Application by Tritax Symmetry (Hinckley) Limited for an Order Granting Development Consent for the Hinckley National Rail Freight Interchange – Deadline 5 submission

Written submission of Oral Case
ISH6 – Traffic & Transport, and Noise

Comments on Applicant's Deadline 4 submission

Written Statement of Oral Case ISH6 [Appendix C – Plan for A47 link road footway/cycleway design]

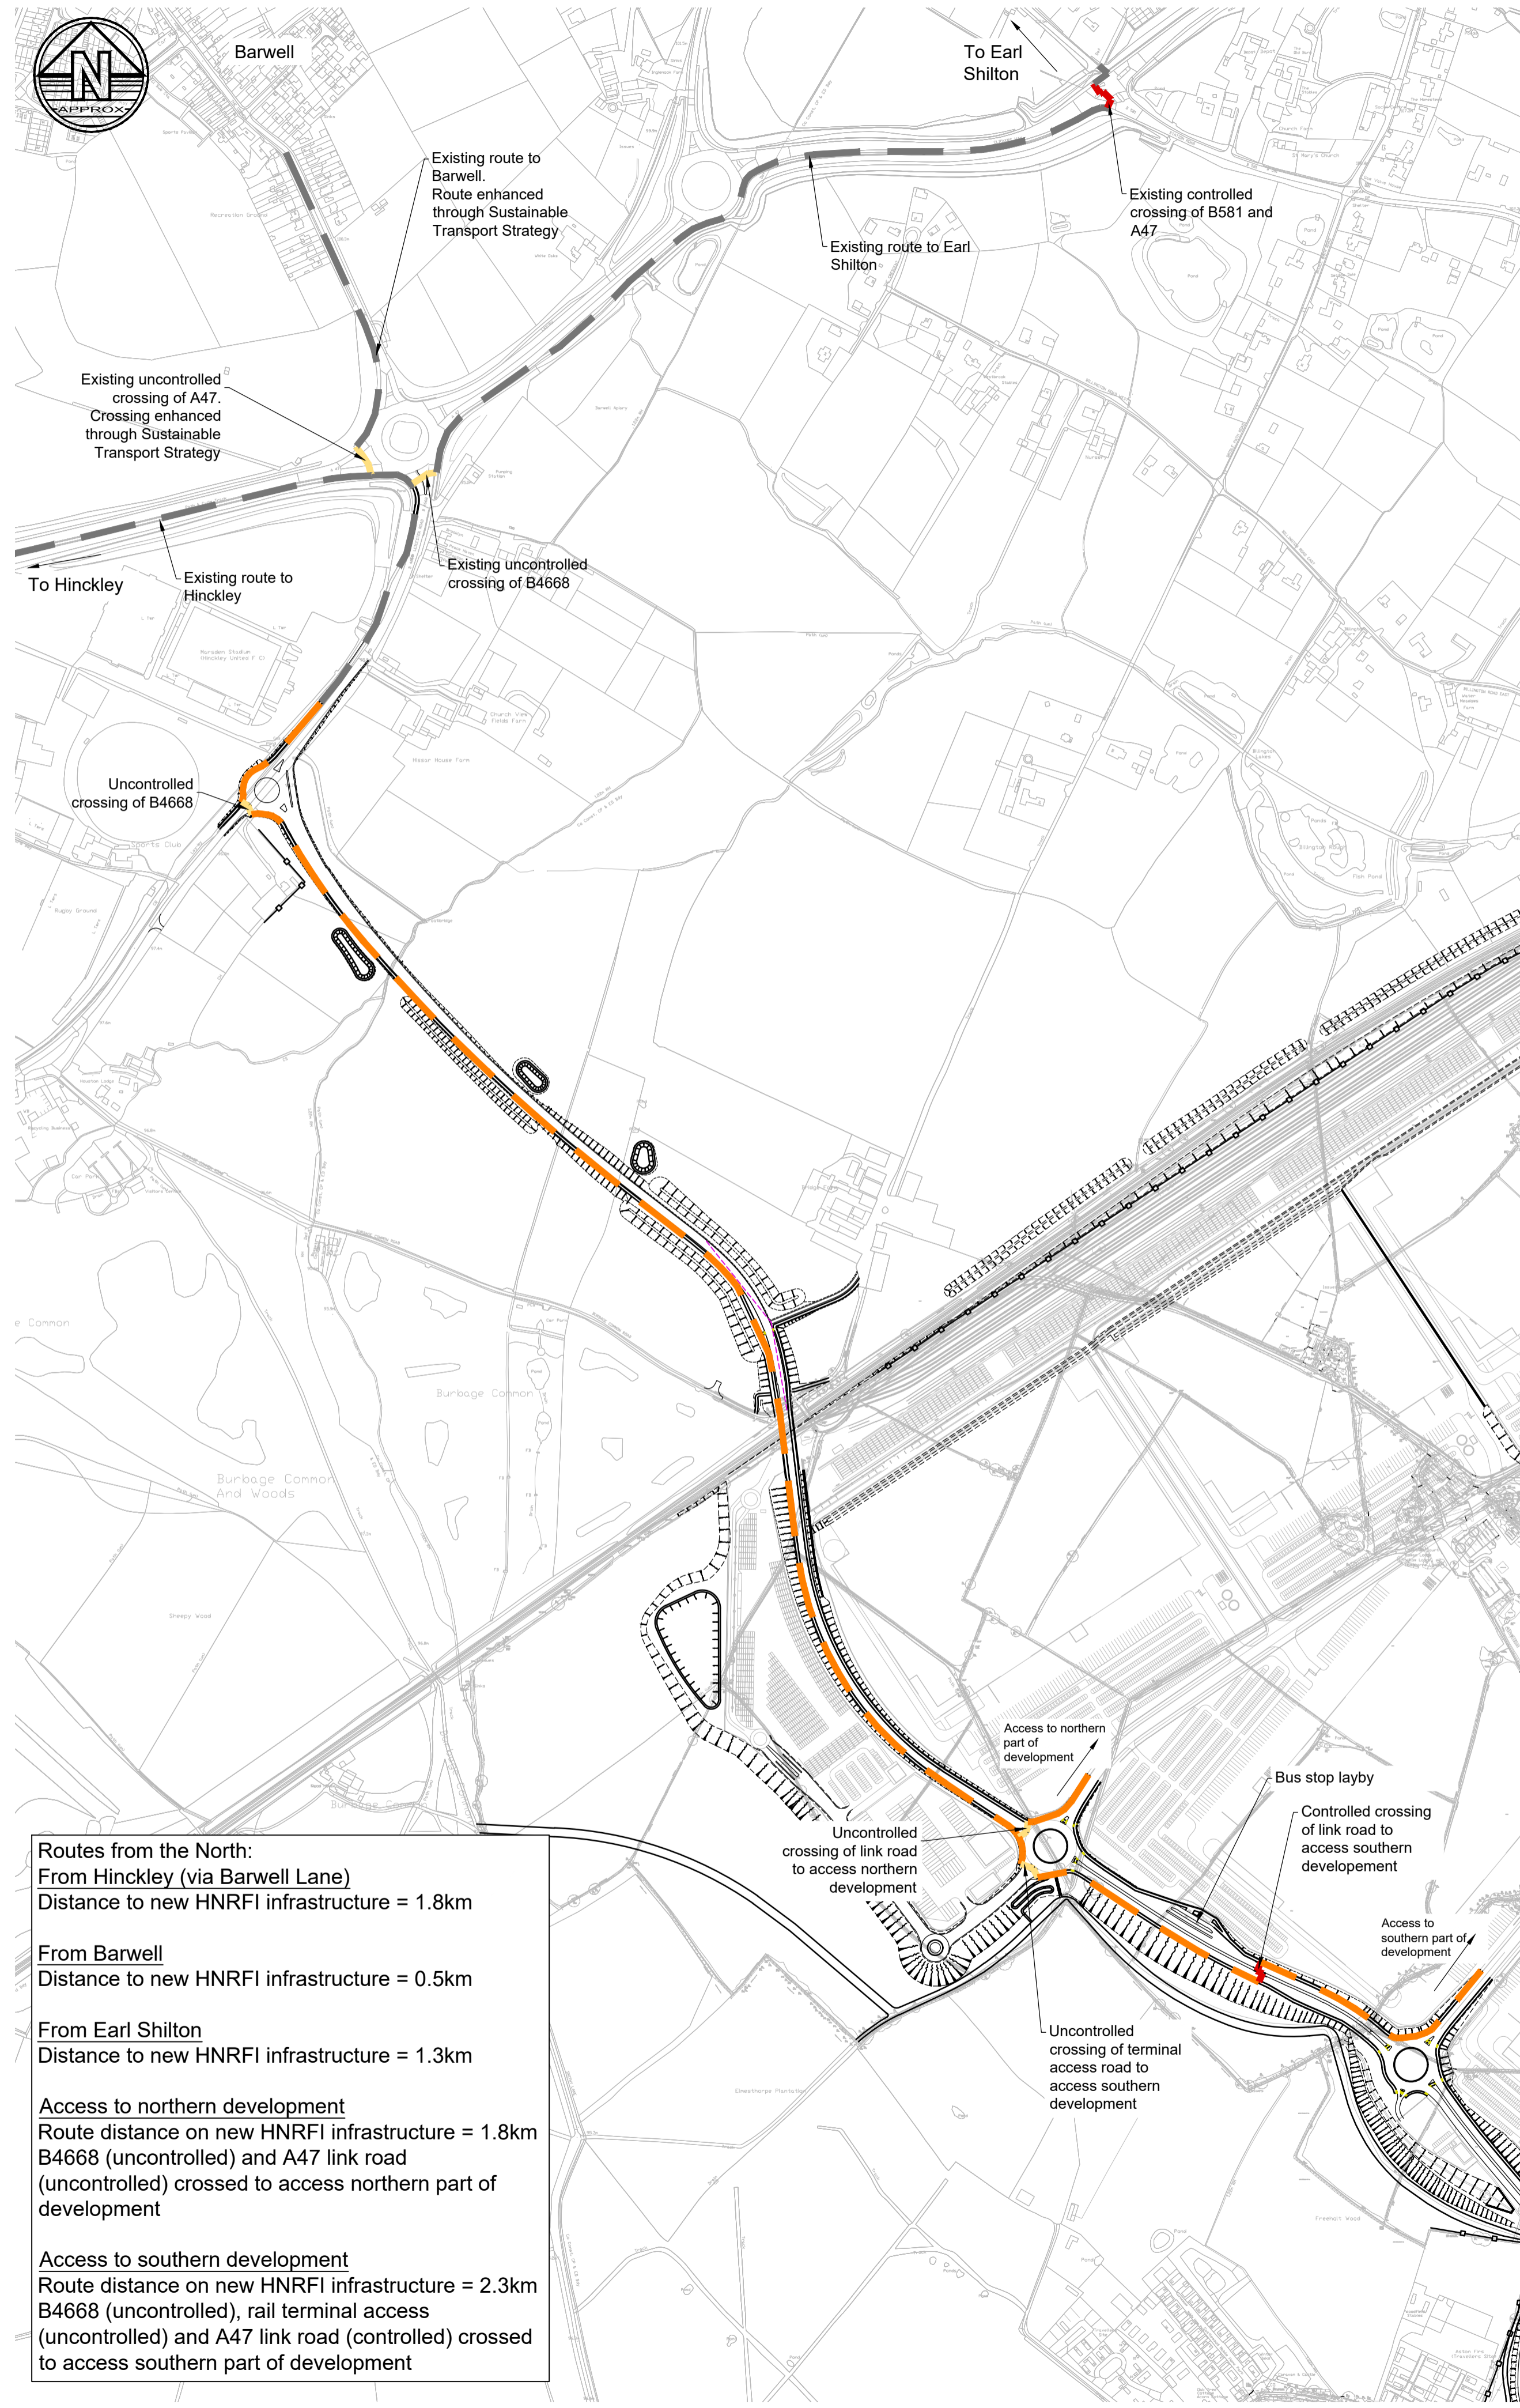
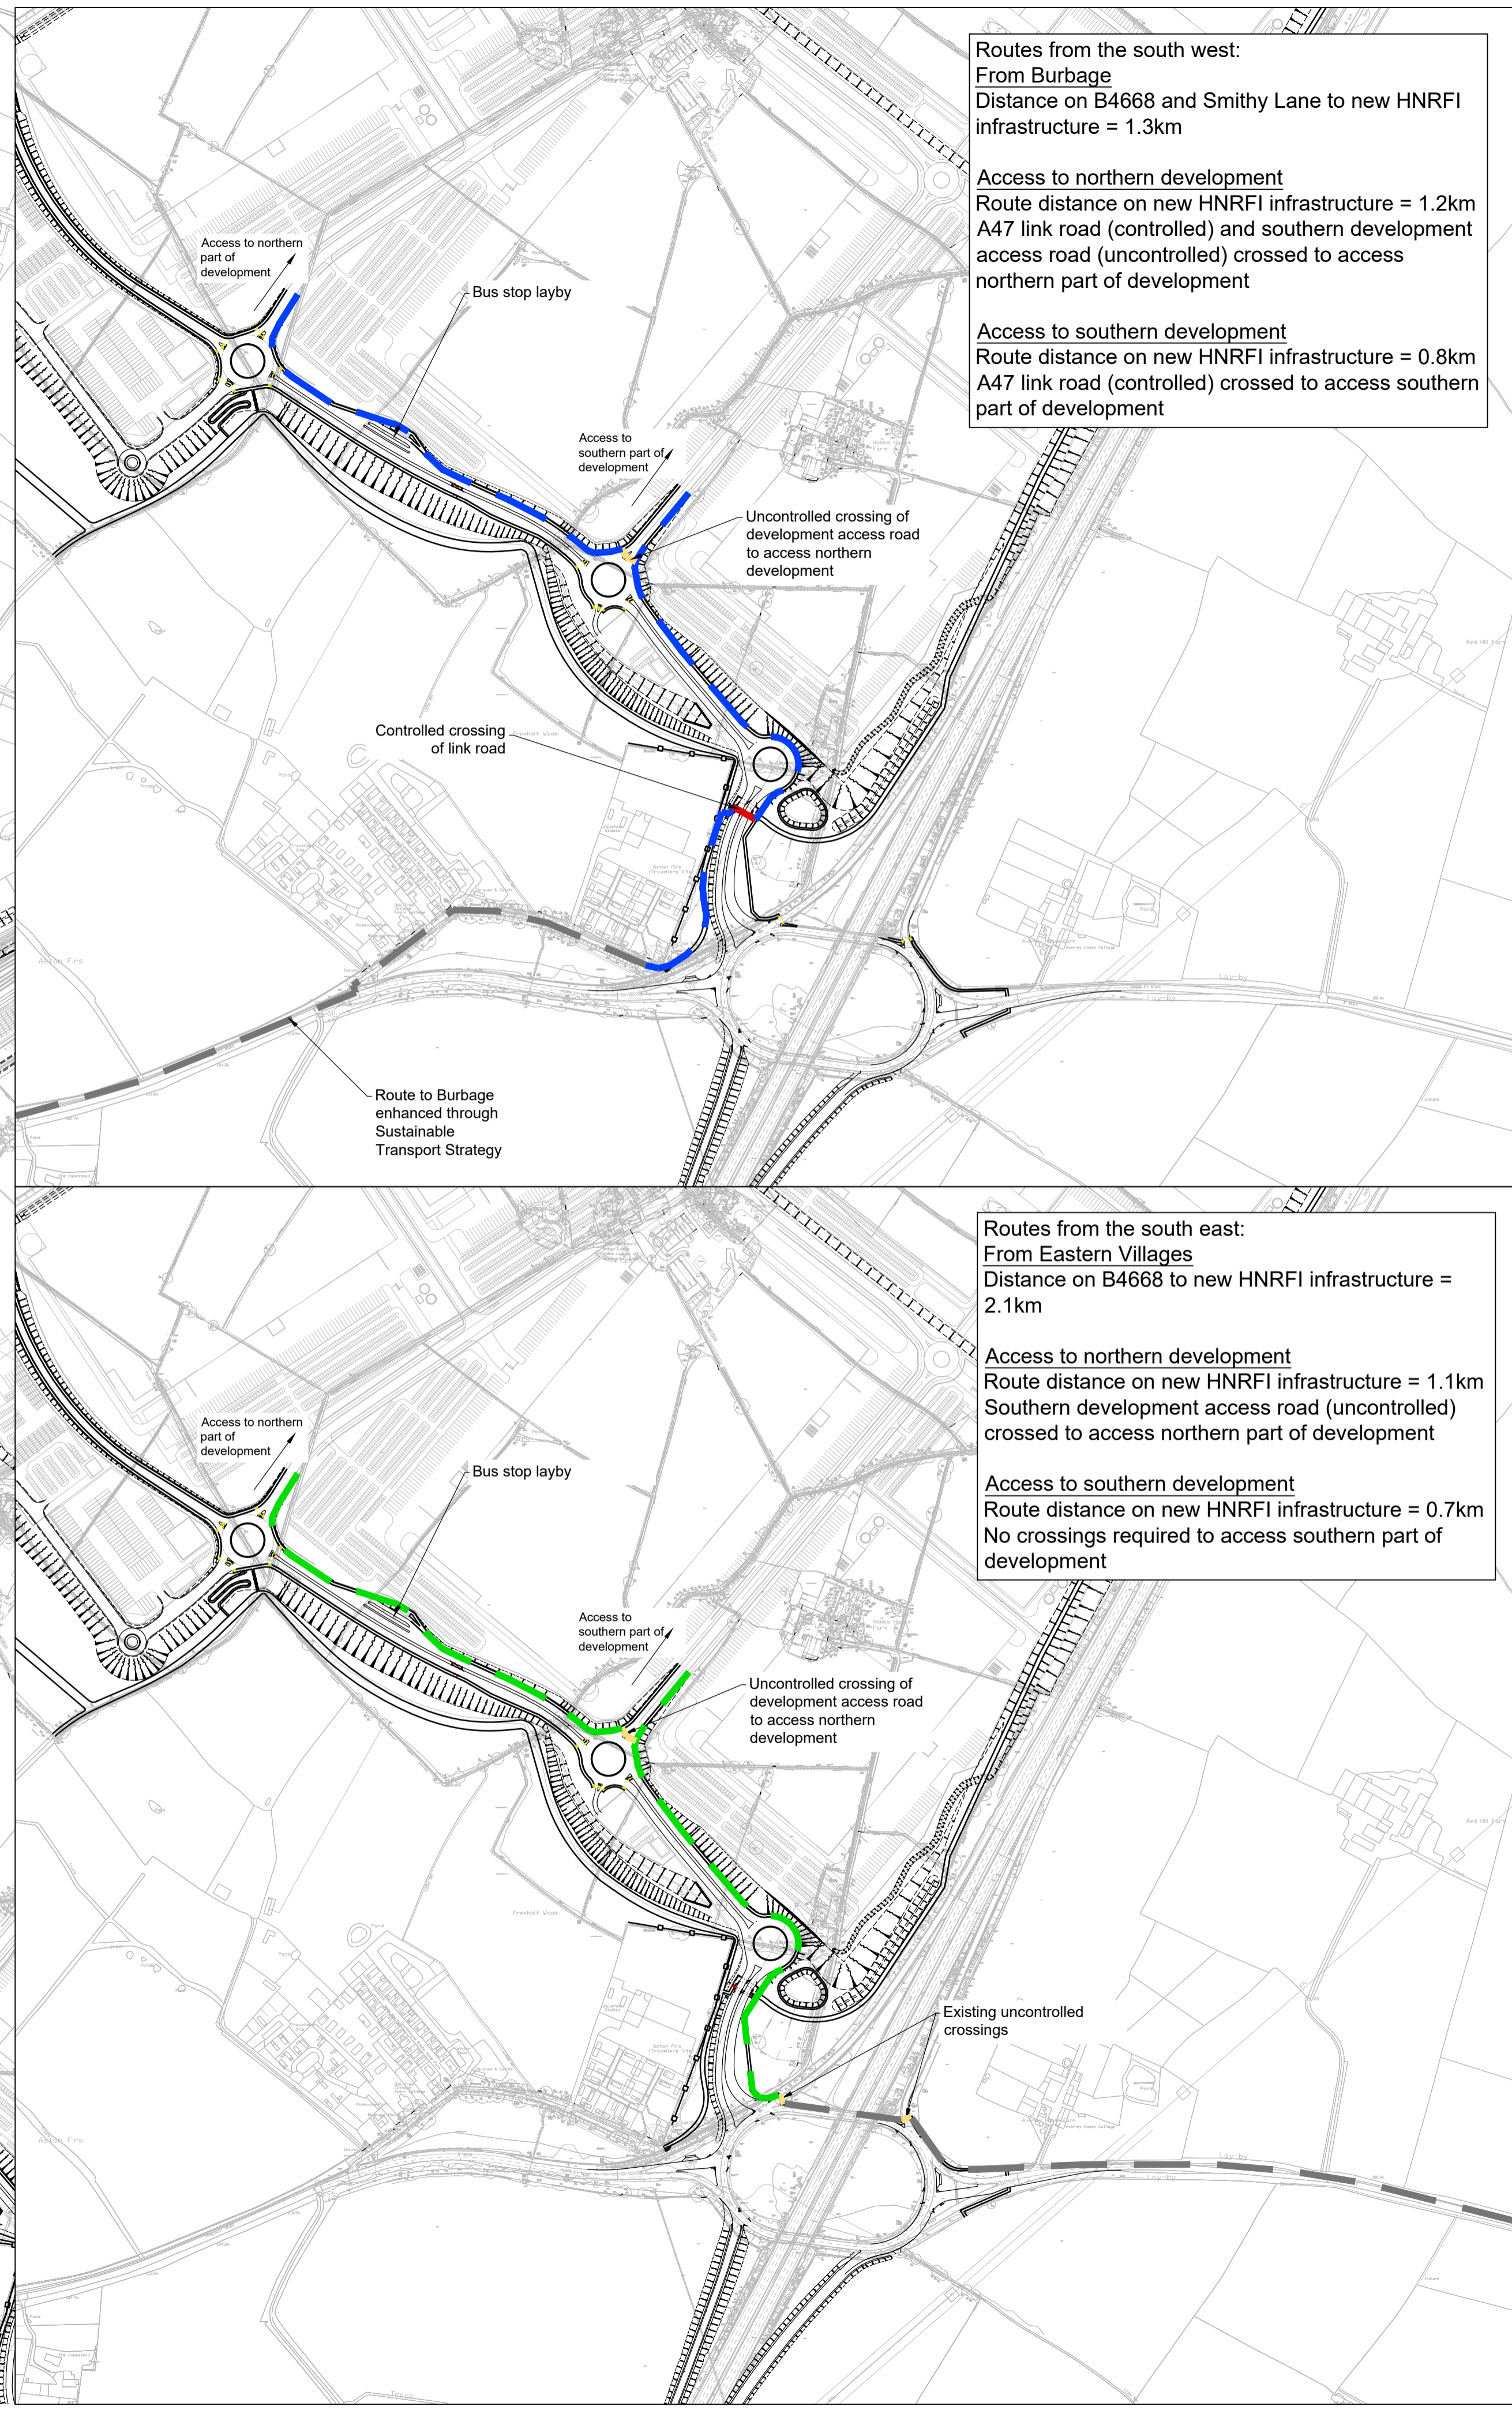
- (i) At ISH2, the Applicant undertook to provide 1:500 drawings of the Link Road but said that there was continuous pedestrian and cycling facilities on each side of the Link Road. LCC has now been provided with the drawings and they do not show continuous pedestrian and cycling facilities on each side of the Link Road. As such, pedestrians and cyclists will have to cross the Link Road in order to navigate it.
